Department of Primary Industries

Our ref: OUT13/29283

Re: 08_0045 MOD 1 - Modification Request - 9 Ada Street Belmont - Lake Macquarie Yacht Club

27 September 2013

STAGE 1 SITE PLAN

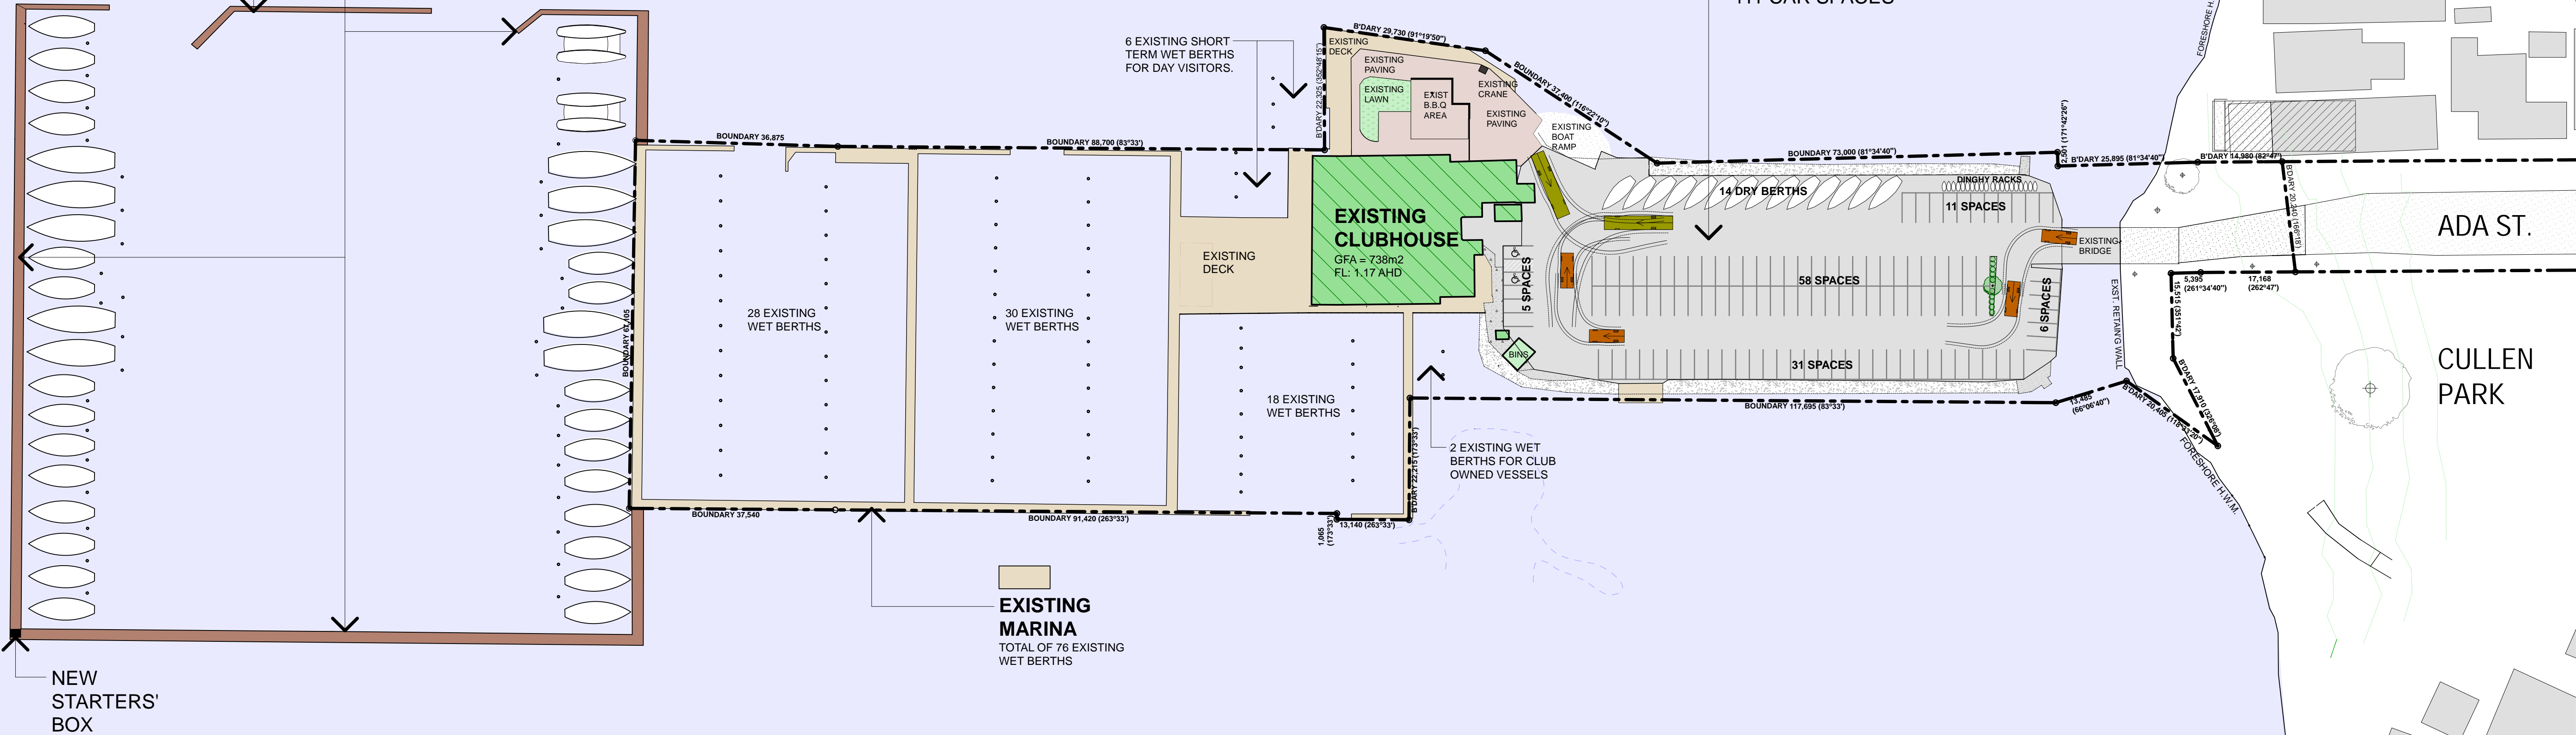
However, the Department does have concerns about the proposal to move the removal of the eight (8) swing moorings from Stage 1 to Stage 3. Given that the staging has no apparent time frames around it, the proposal to maintain these swing moorings until they get around to Stage 4 will not achieve the intended environmental benefit of removing them.
